July 11, 2019

Re: Project #PR-2019-002496 for Southeast Corner of Alameda Blvd. NE & Barstow Street NE

It has been brought to the attention of our Vineyard Estates Neighborhood Association that an application by Consensus Planning for a site plan on behalf of Philip Lindborg for development of 93 apartments on the southeast corner of Barstow Street NE and Alameda Blvd. NE is set for a Development Review Board hearing on July 17, 2019. It is our understanding that the property zoning is MX-L under the current IDO and this application is a permissive use of the property.

1 Site Plan - West
1" = 20'-0"

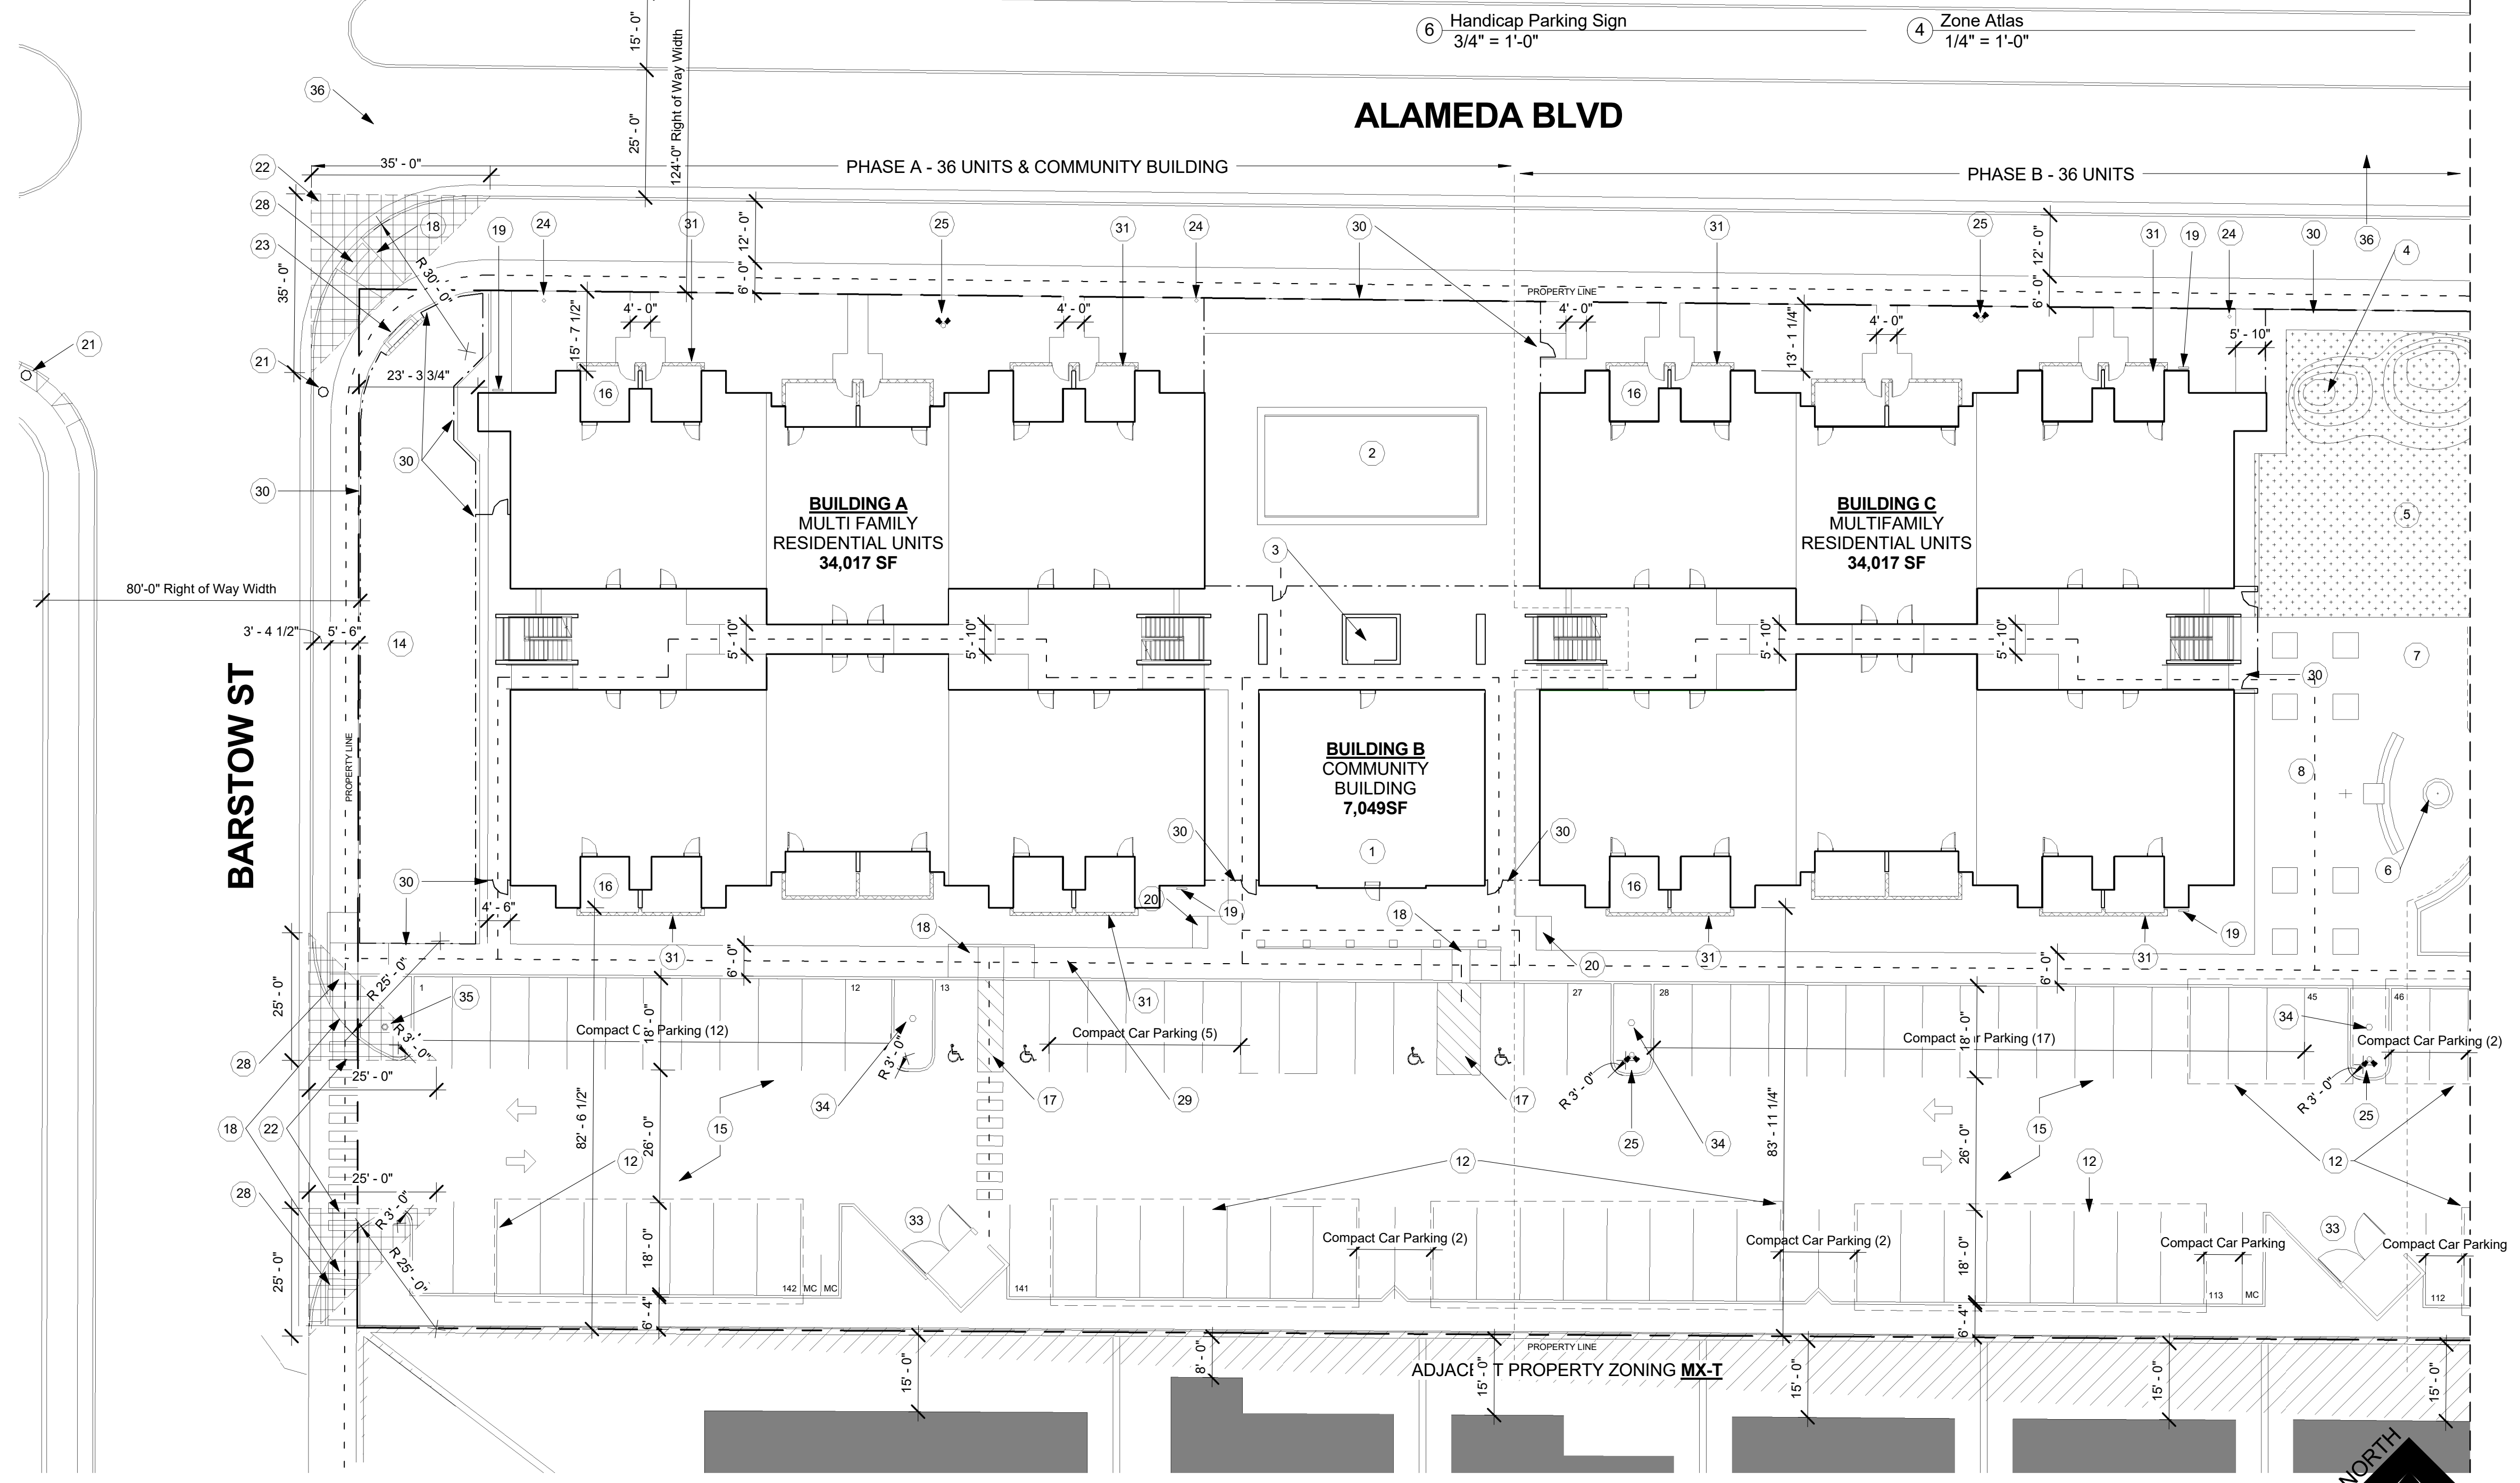
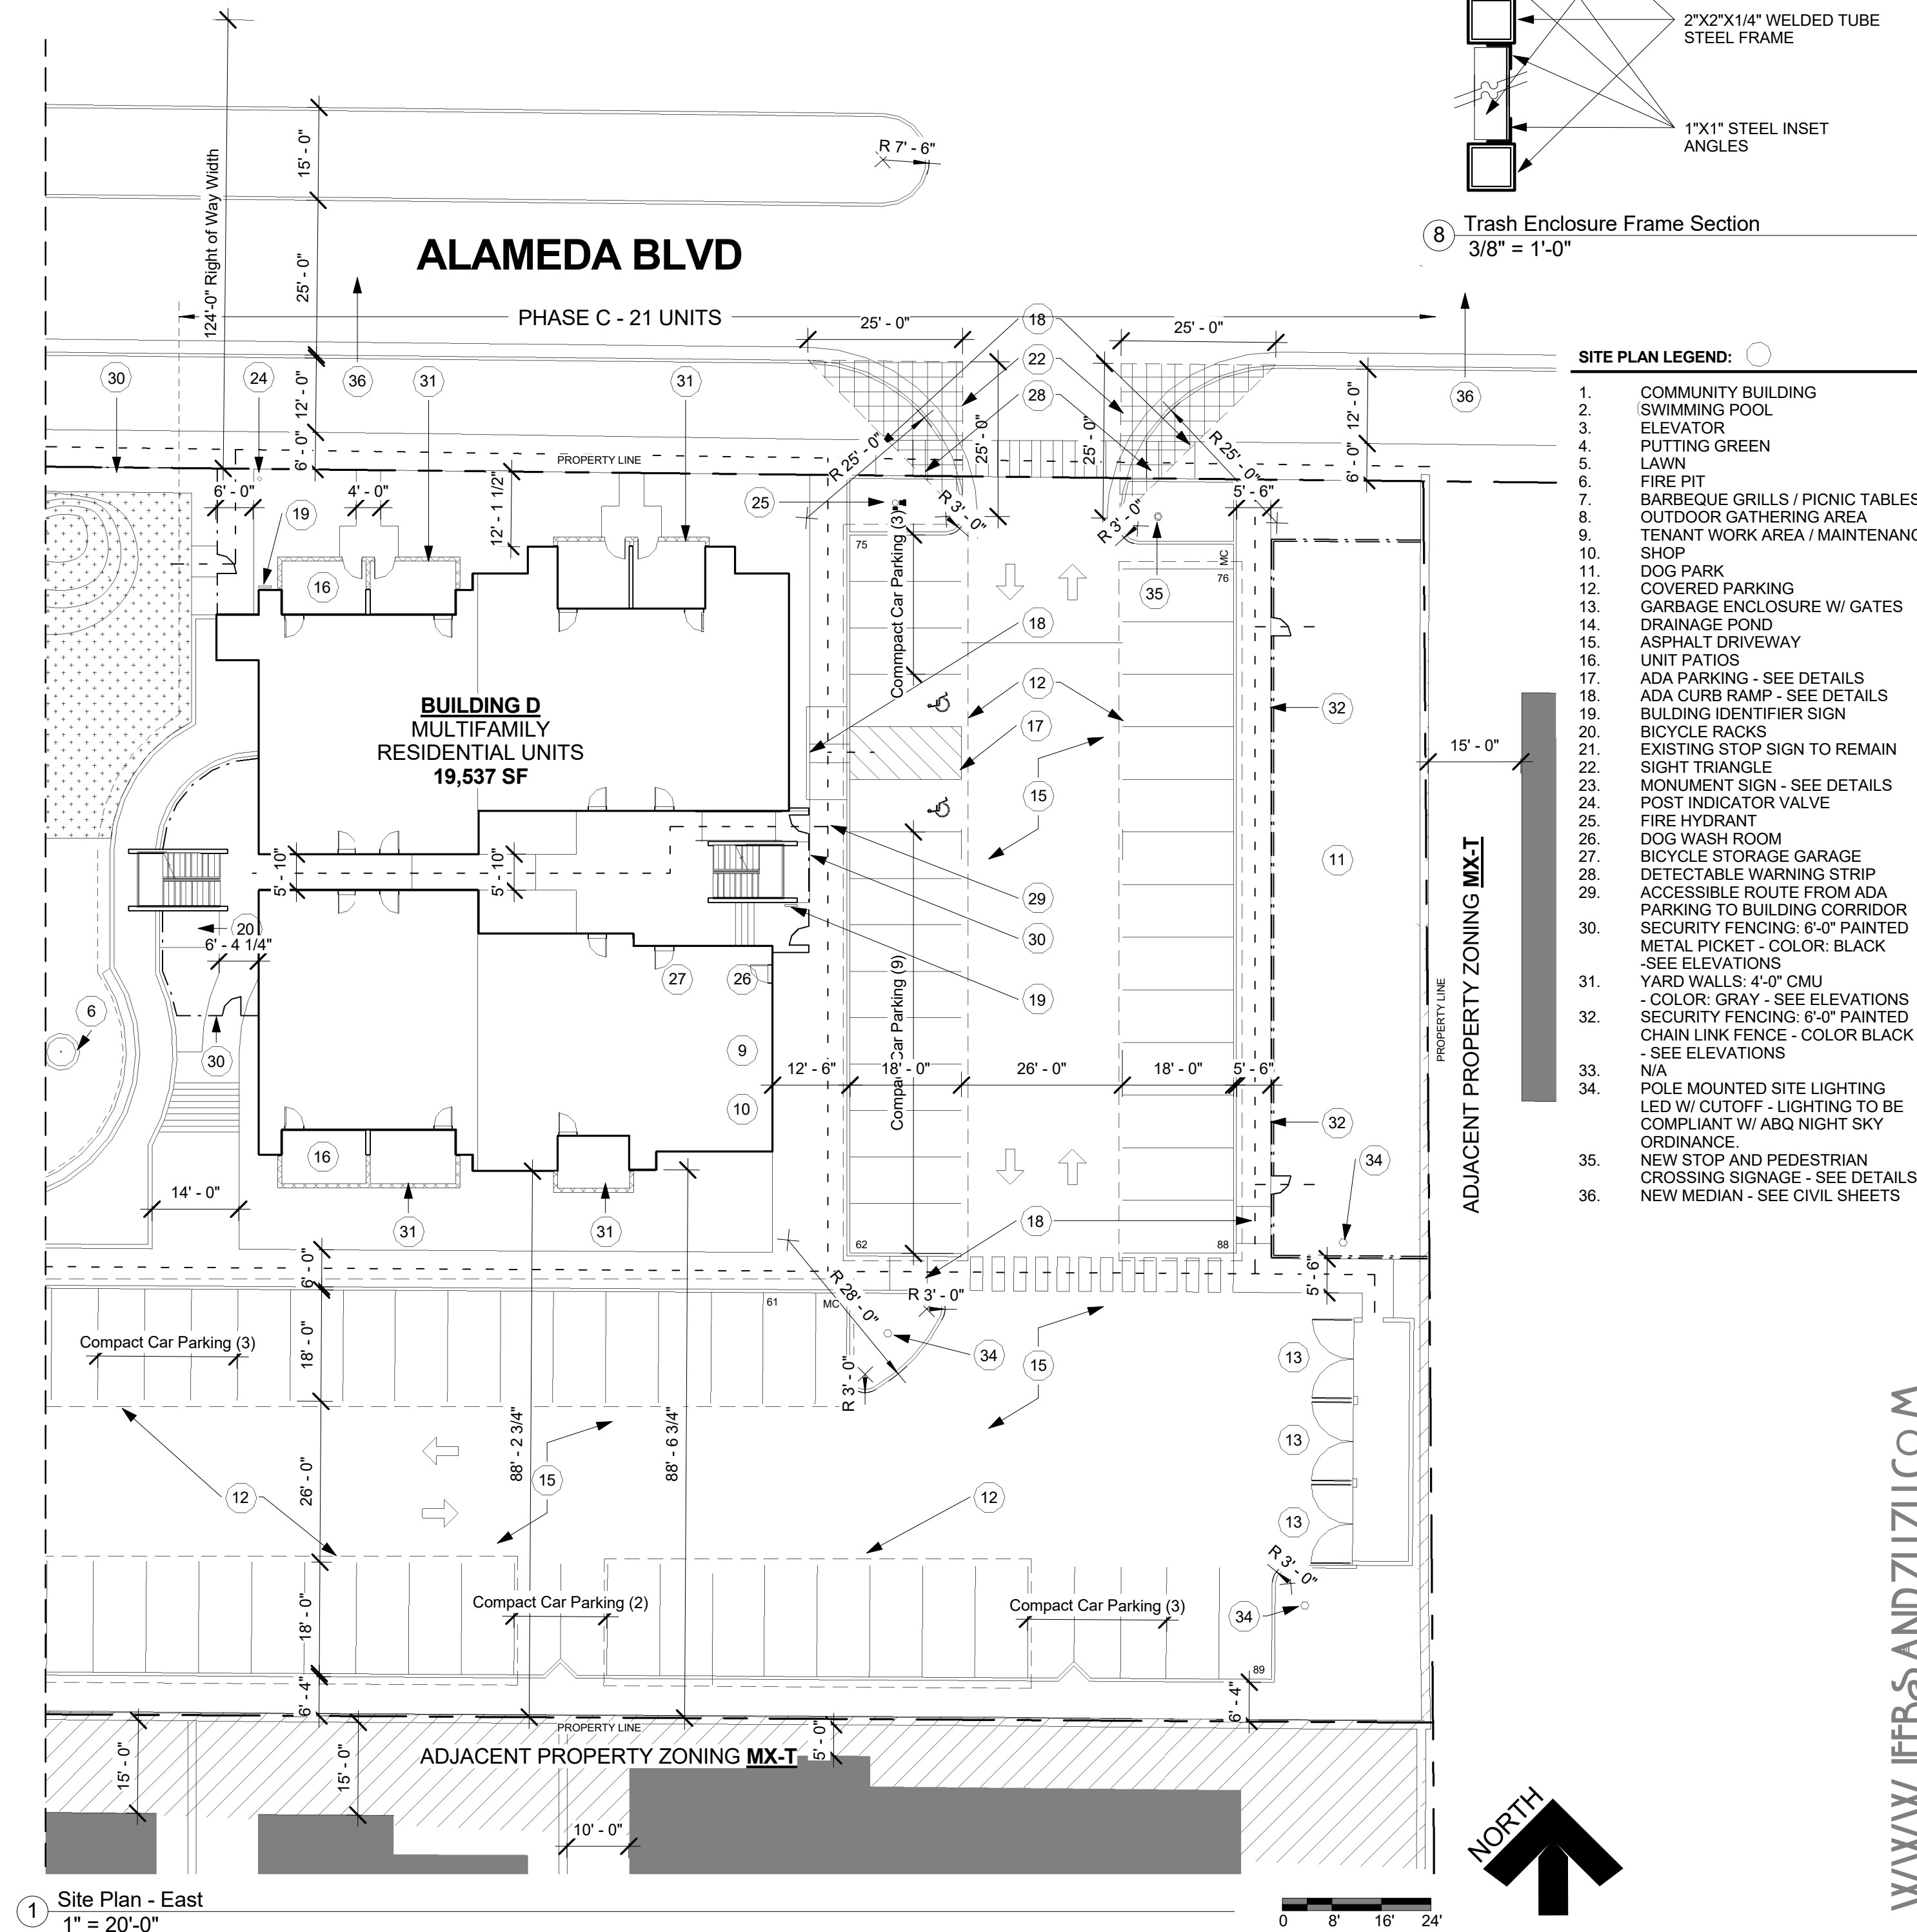
- 1) **Inadequate parking:** Neighbors are very concerned where the overflow of parking will end up if and when tenants have more than one car or a visitor. Alameda and Barstow offer no legal parking however side streets could fill in with parking creating jaywalking and disruption. Additionally, the parking lot is not secured with a gate comparable to other nearby apartment complexes.

- 2) **Encroachment of rear wall of southward located properties:** Homeowners directly affected by this development (to the south) have concerns over the location and height of the carport in relation to their rear wall height and may be looking into the carport as their “view.” Also, landscaping trees may uproot the rear privacy wall or grow into the homeowners yard uninvited, while also destroying the home owner’s property values by having their yard enveloped by both the carport and 3-story apartment complex.

- 5) ***Dumpster and Garbage Location:*** While it is noted that the developer has tried to accommodate garbage and recycling locations to help reduce smell, noise, and nuisance, there will still be a problem to the Tierra Morena neighbors due to the proximity of these dumpsters to their rear properties. Garbage trucks feet from the south property owner’s rear walls, as well as sour odors radiating from week old garbage make it difficult to see how this accommodation solves this problem for the very near neighbors.
